11 August 2026

Re: State Significant Development Application No.SSD-82160220 (184 Fifth Avenue, Austral)

The Department of Education (the department) welcomes the opportunity to provide comments on the above State Significant Development Application (SSDA) and concurrent rezoning proposal (RP).

SHADOW DIAGRAM - 21 JUNE-3PM
SCALE: 1:1500@A1

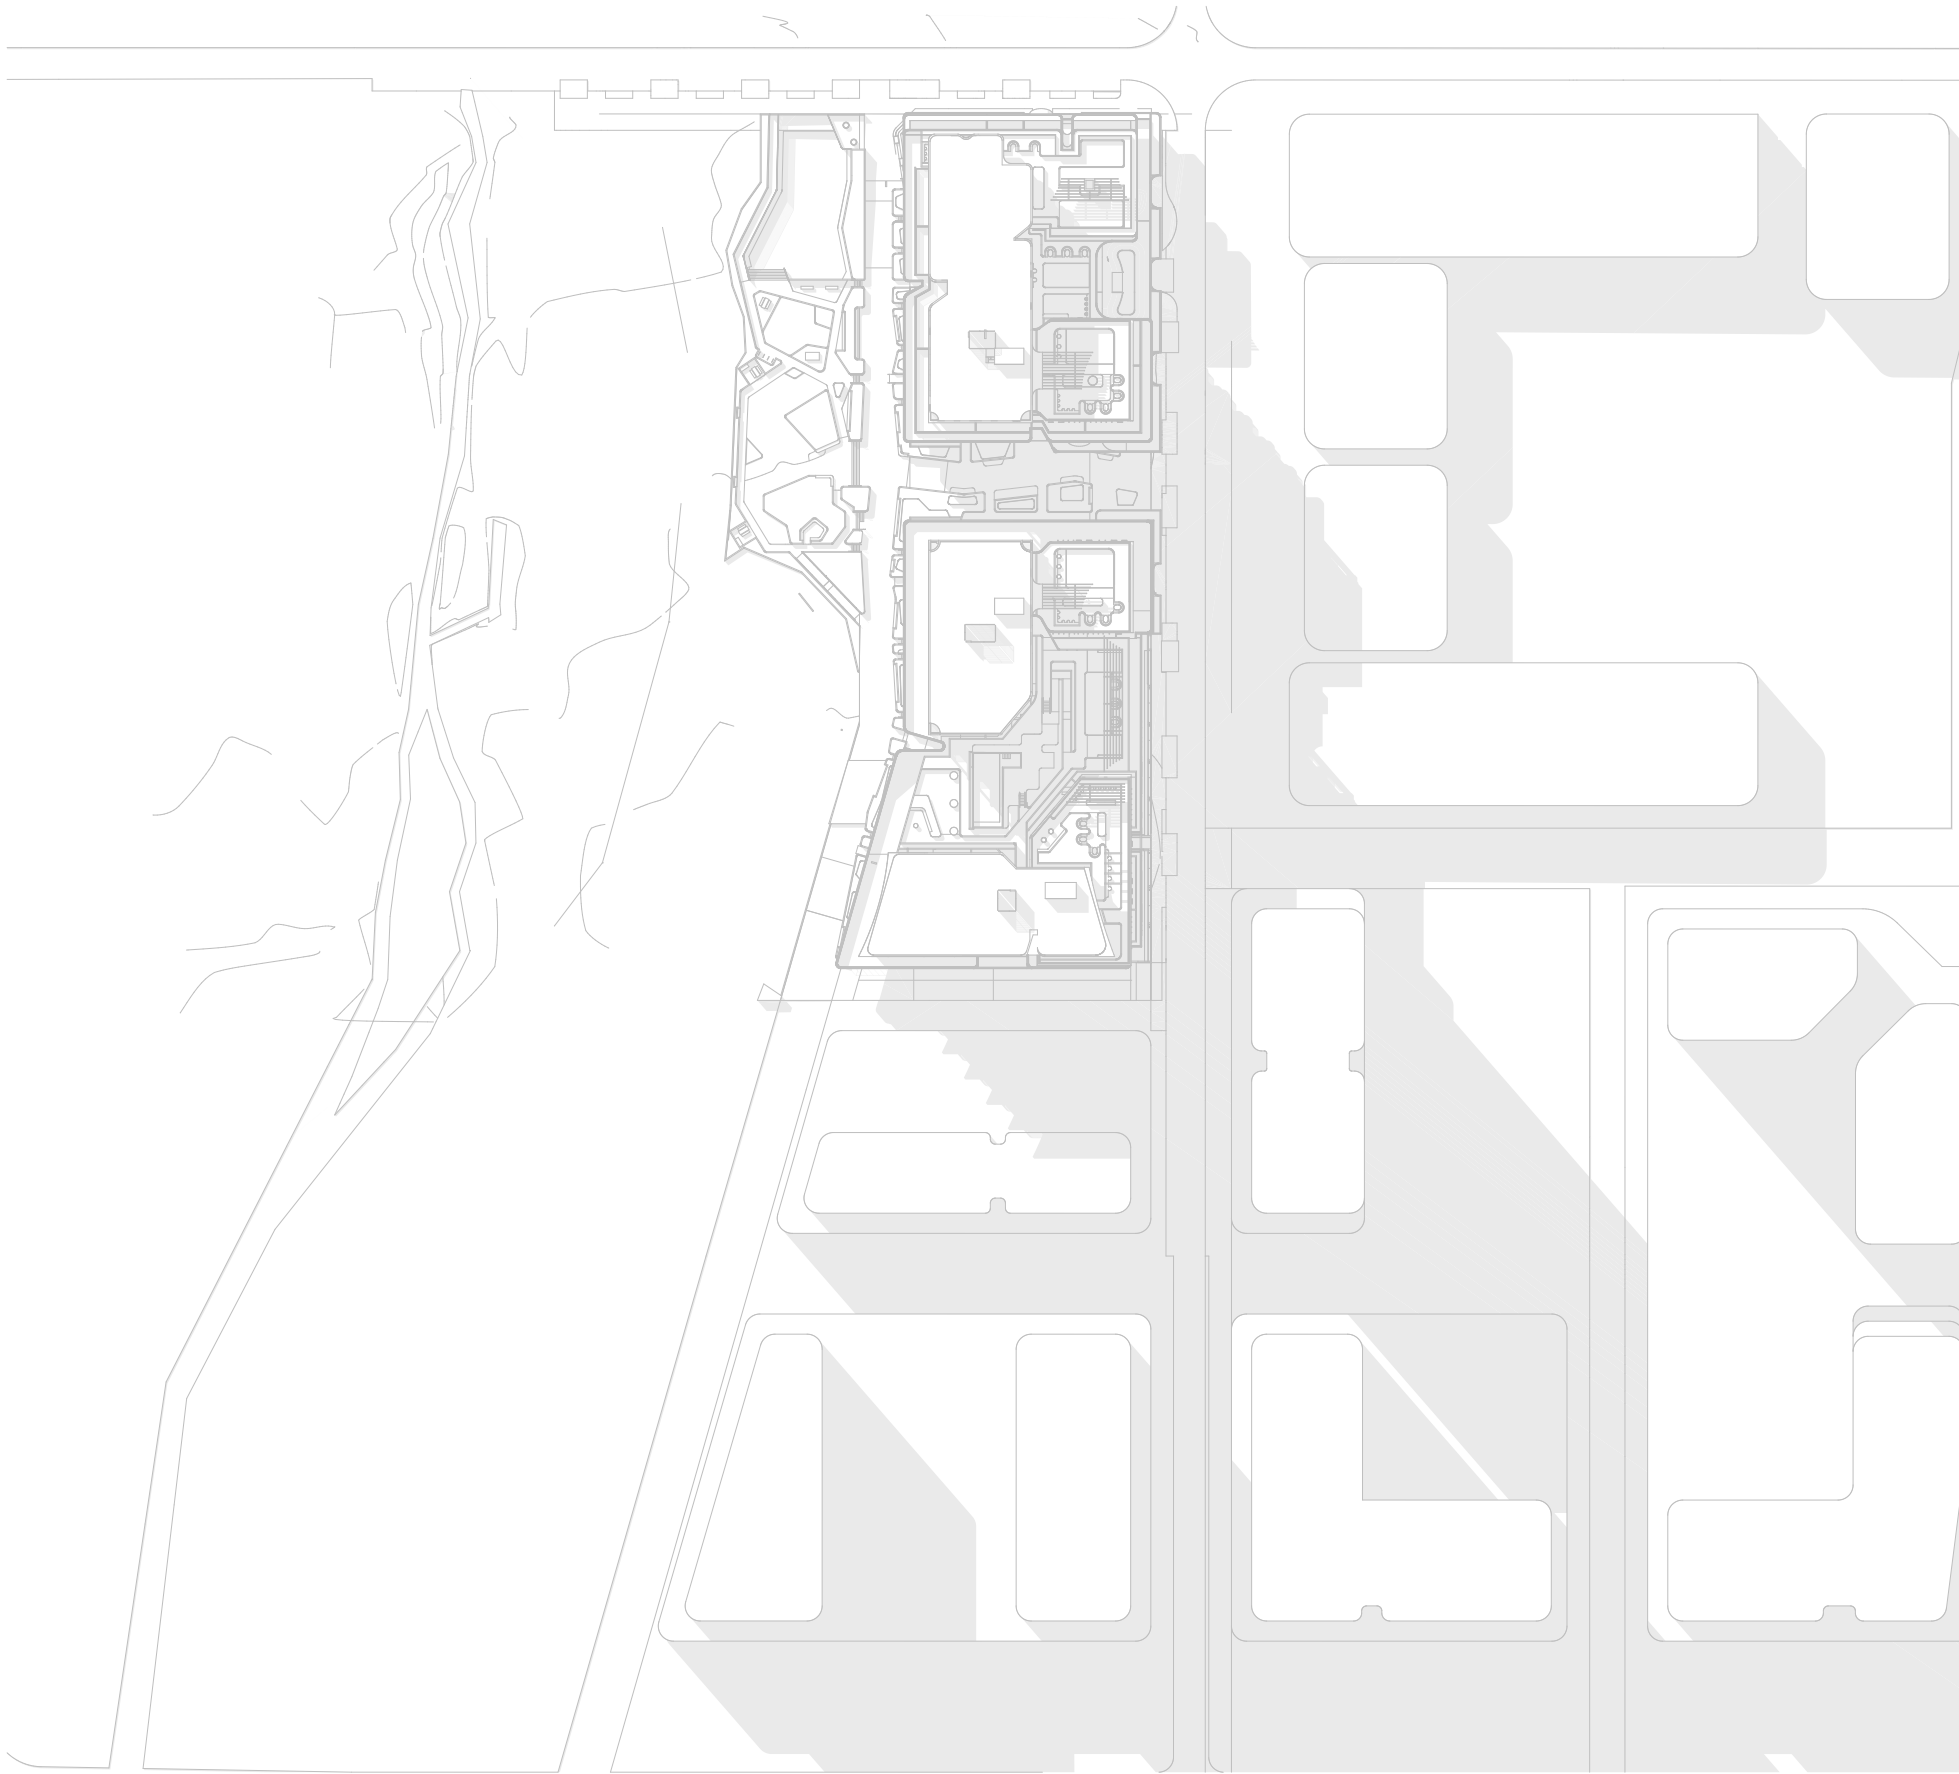
Overshadowing

The proposed development and rezoning propose significant up-lift in building height beyond that currently provided in Western Parkland City SEPP.

The siting and design of all proposed buildings should not have unreasonable overshadowing impacts on the proposed public school and public early learning facility. In particular, the development should ensure that the open play space areas and classroom buildings are not negatively impacted by overshadowing during school hours.
